April 3, 2017

**Baxter Academy Interior Fit-up - Response to Permit Review
Comments**

185 Lancaster Street, Portland, Maine

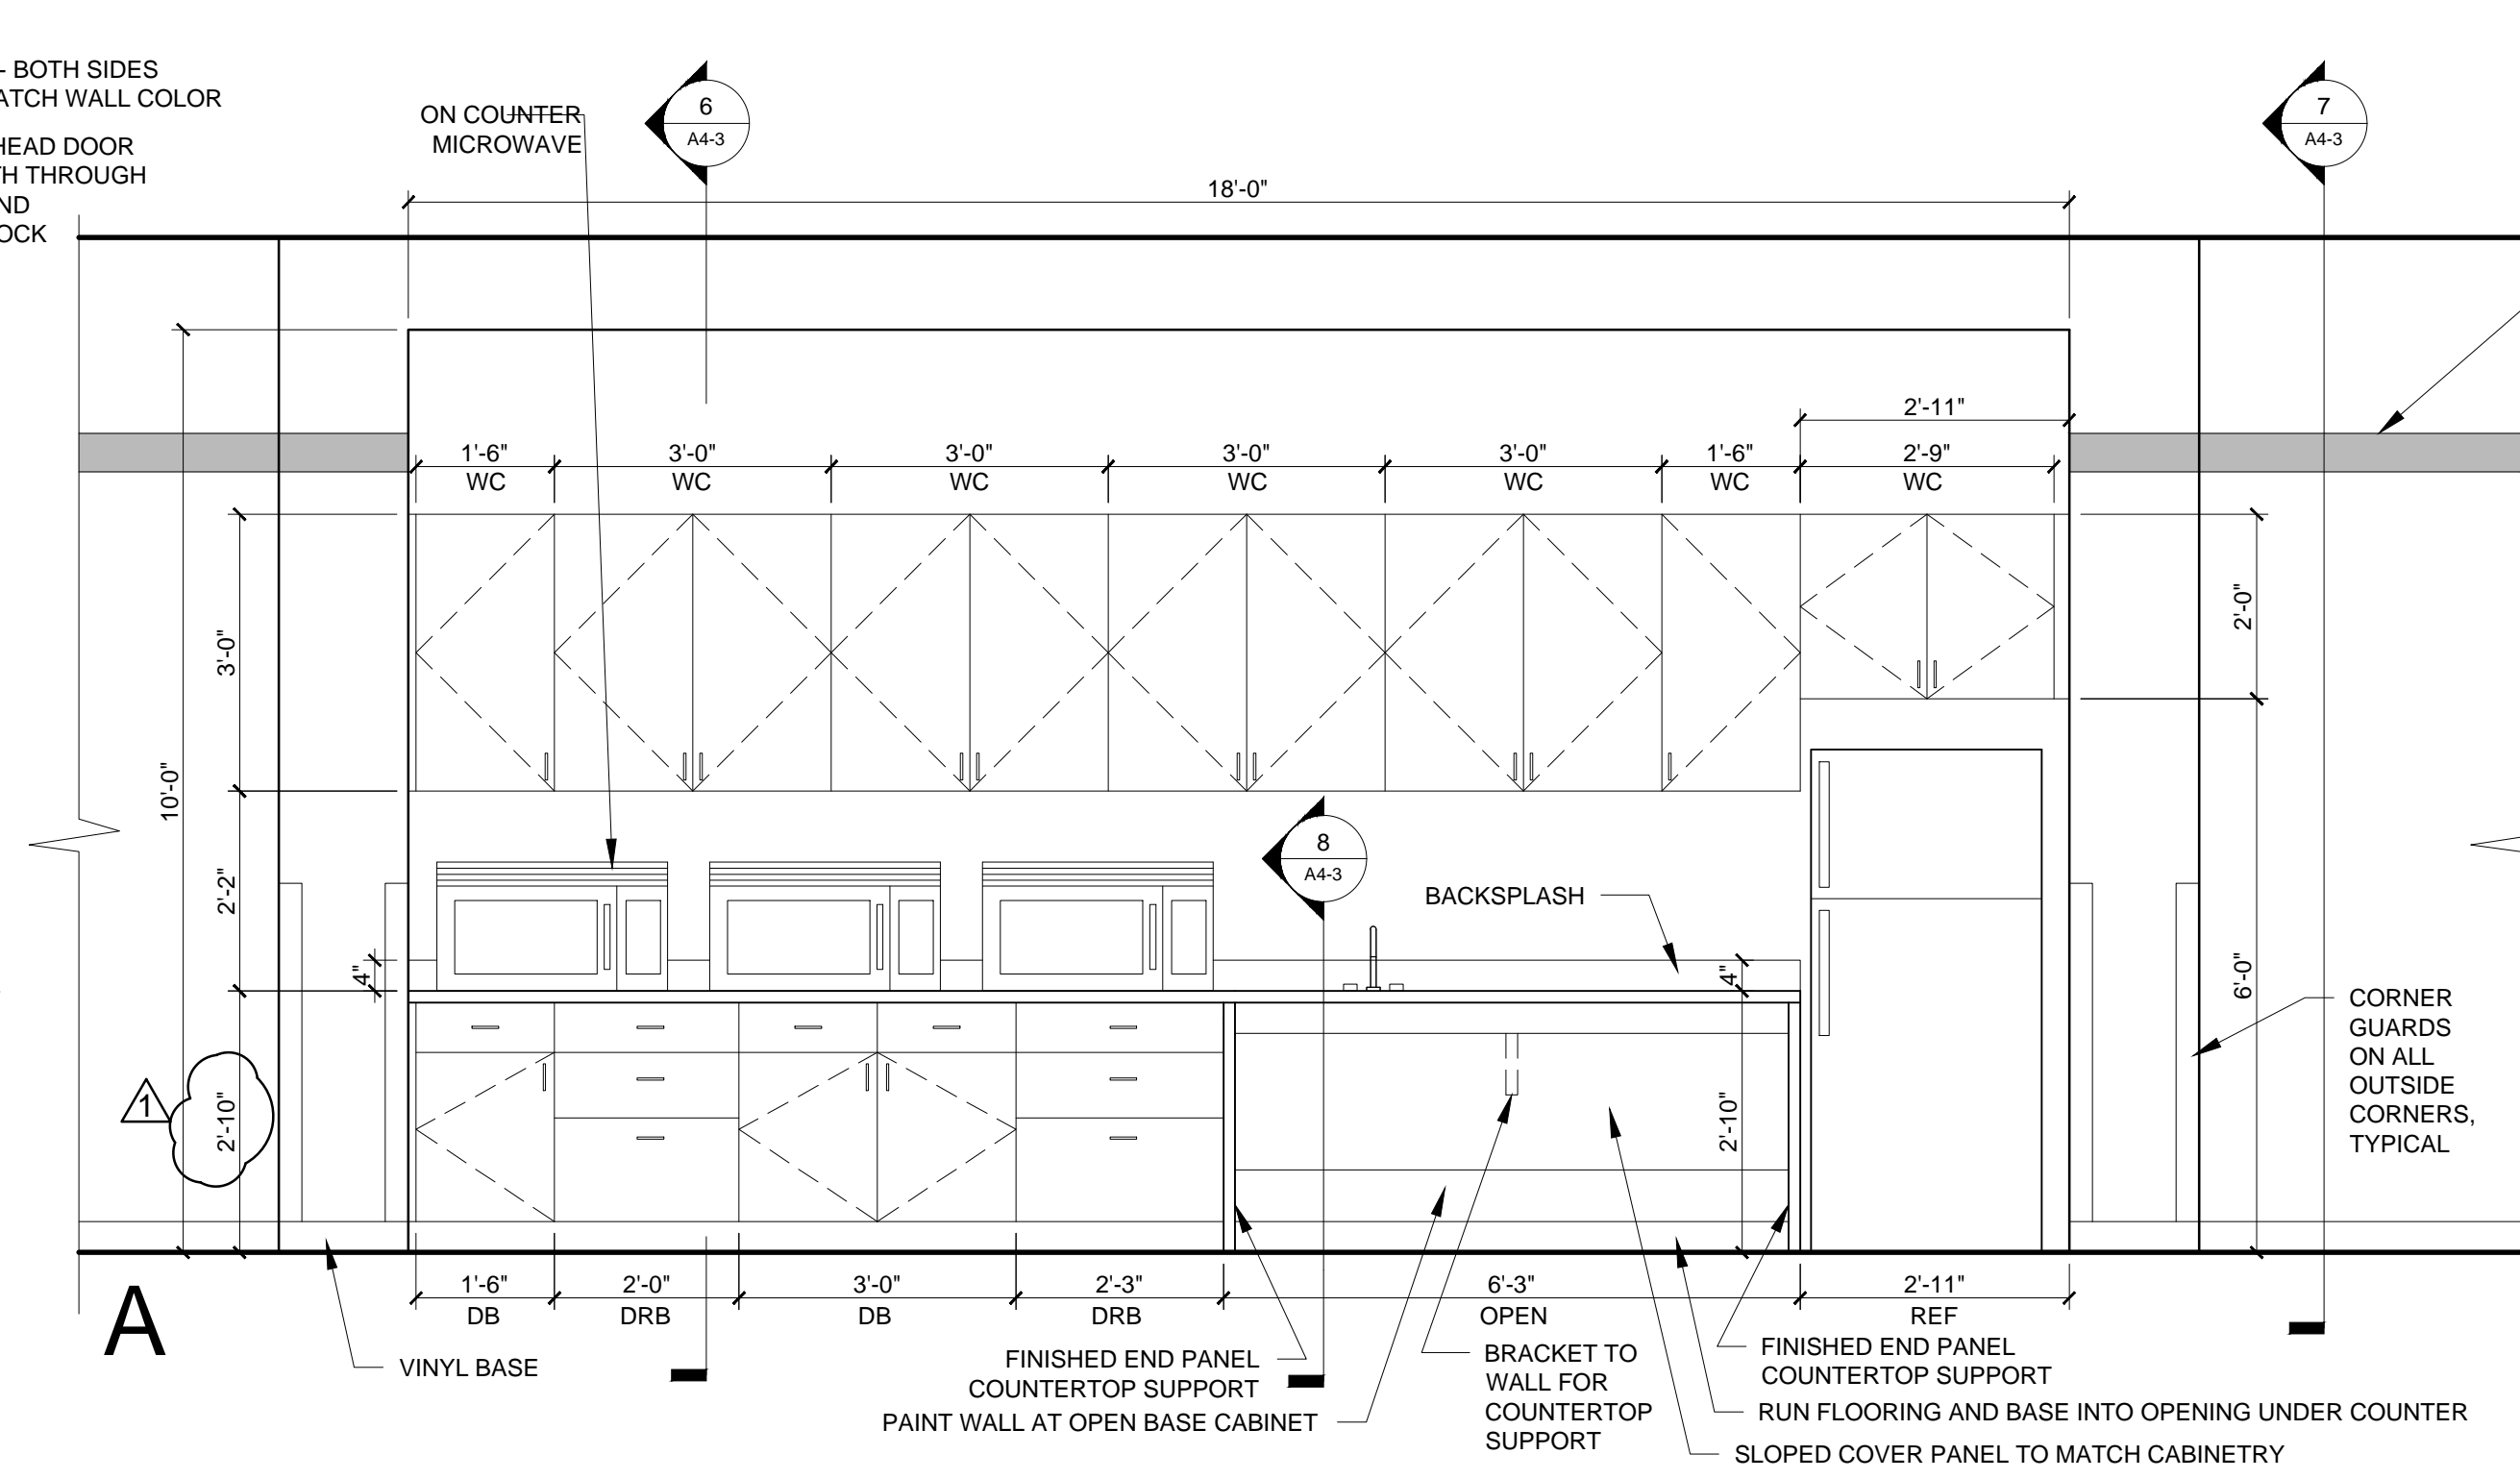
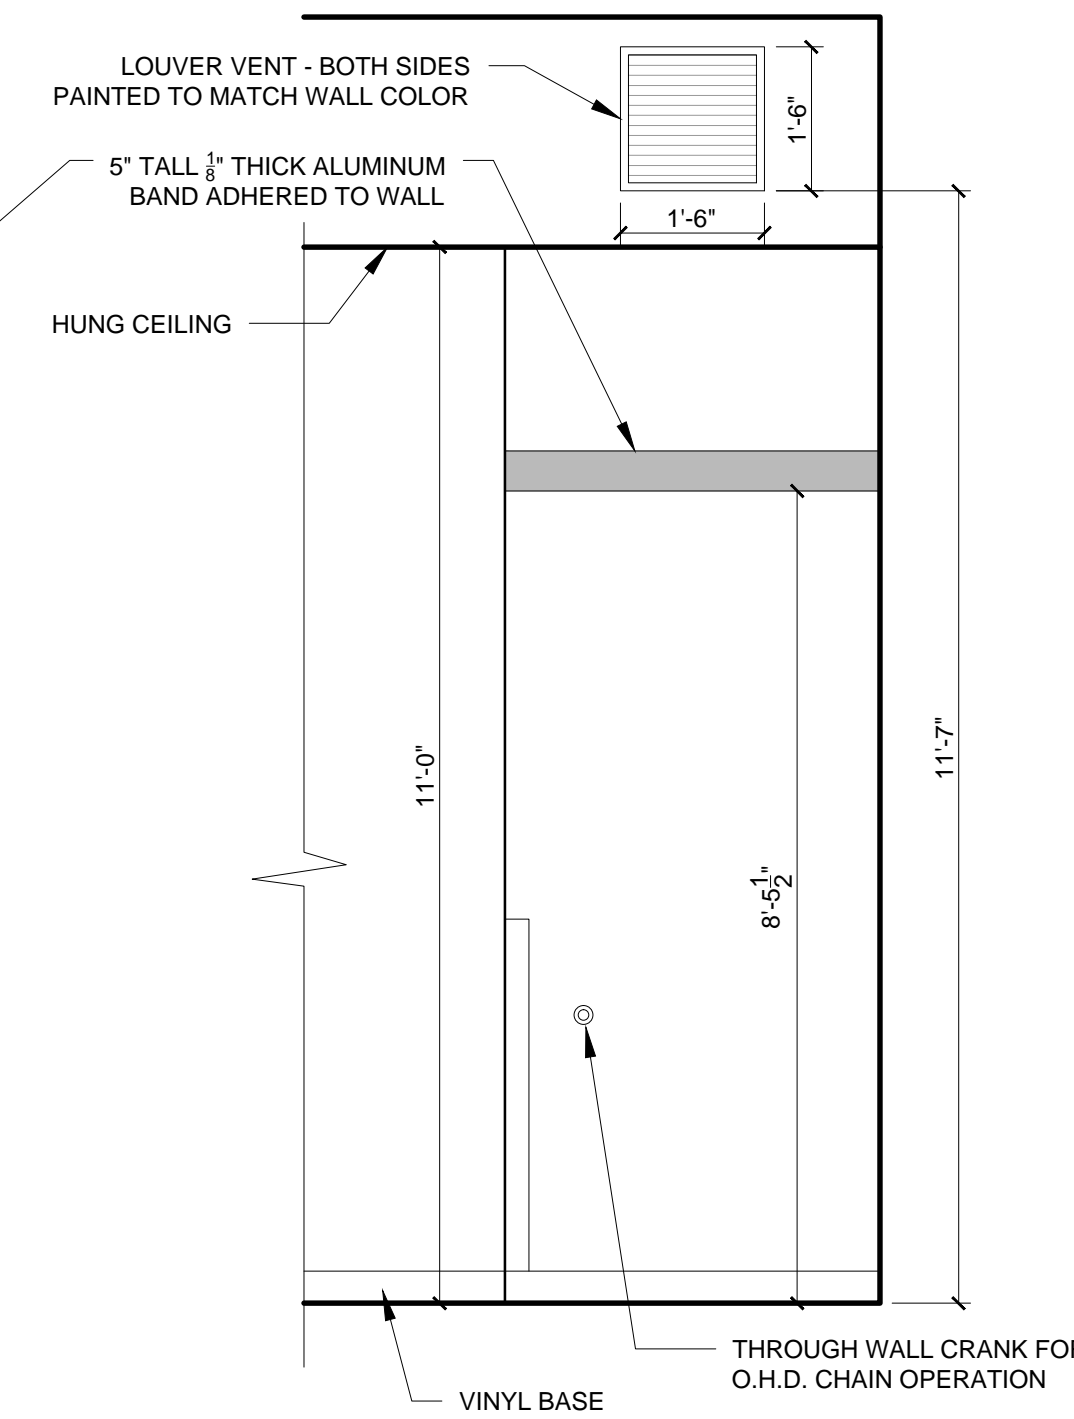
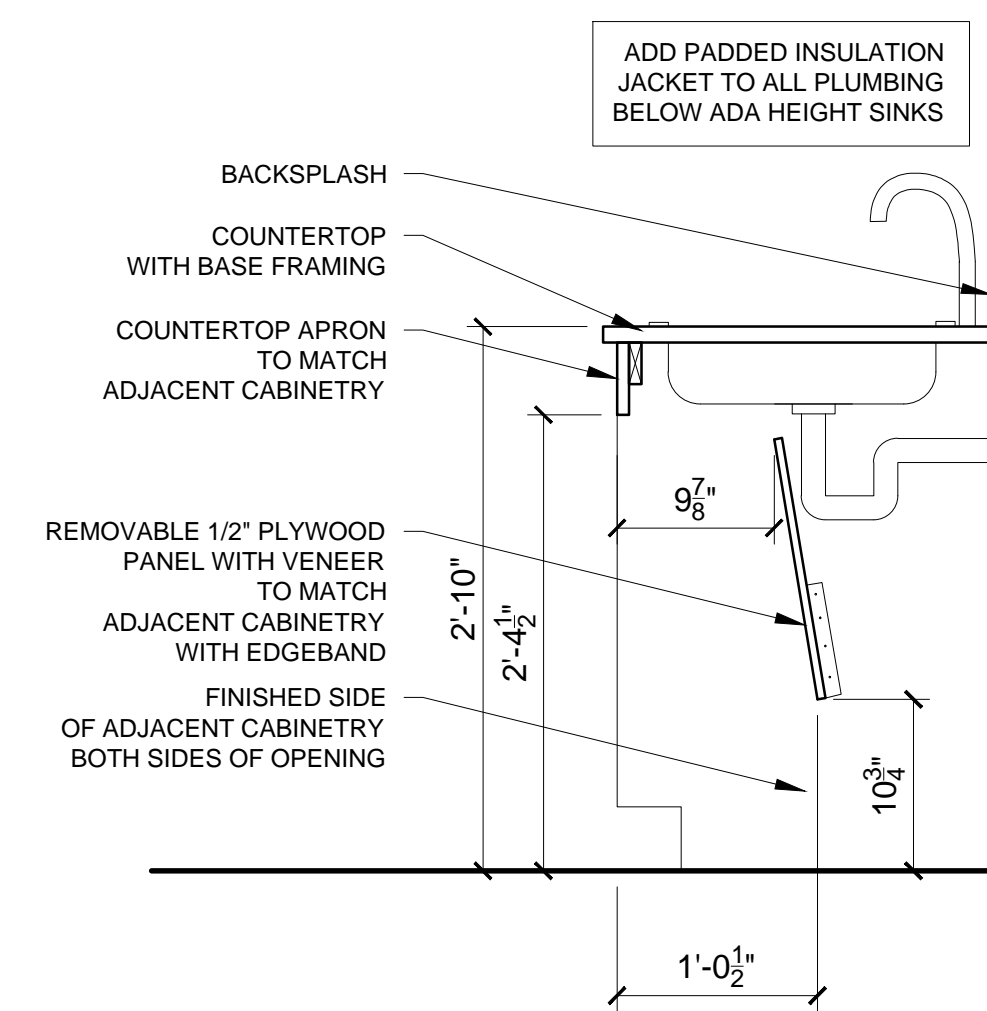
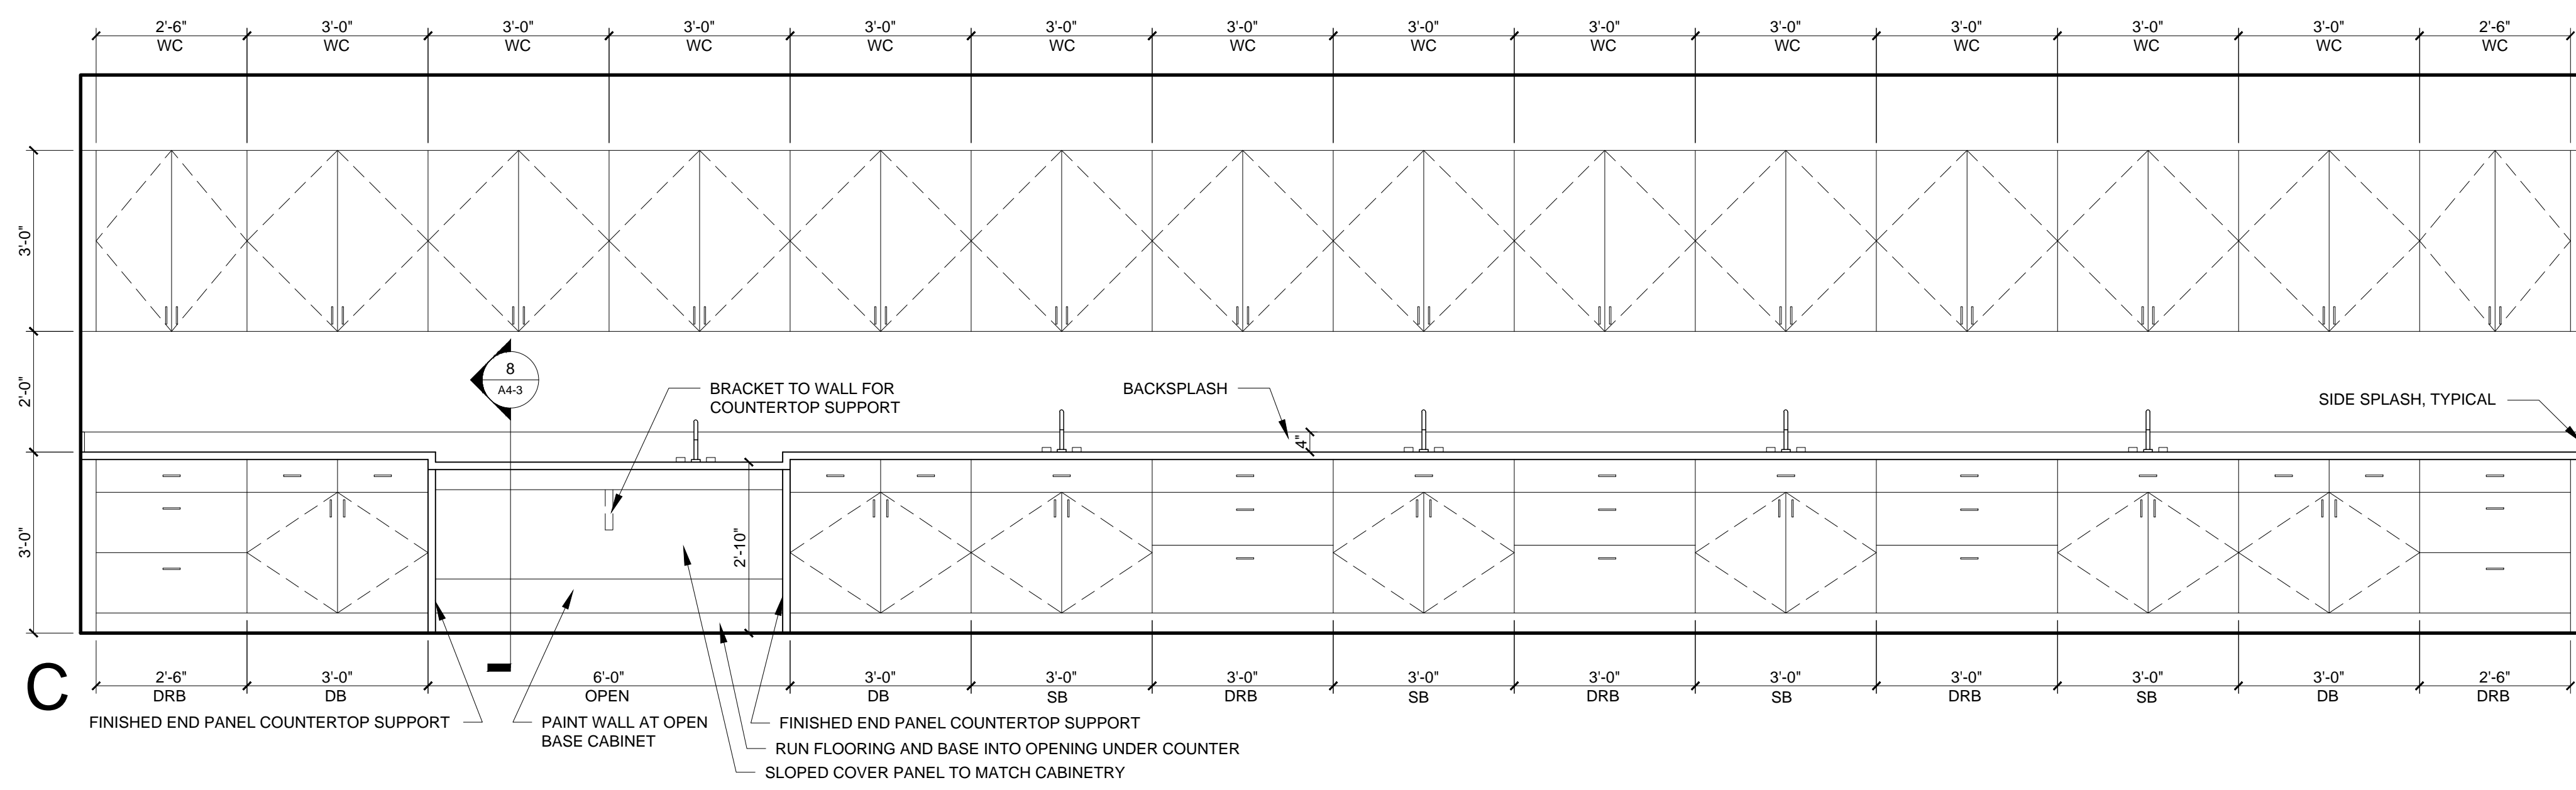
A4-3:

- We have revised the kitchenette cabinetry to 34" aff.
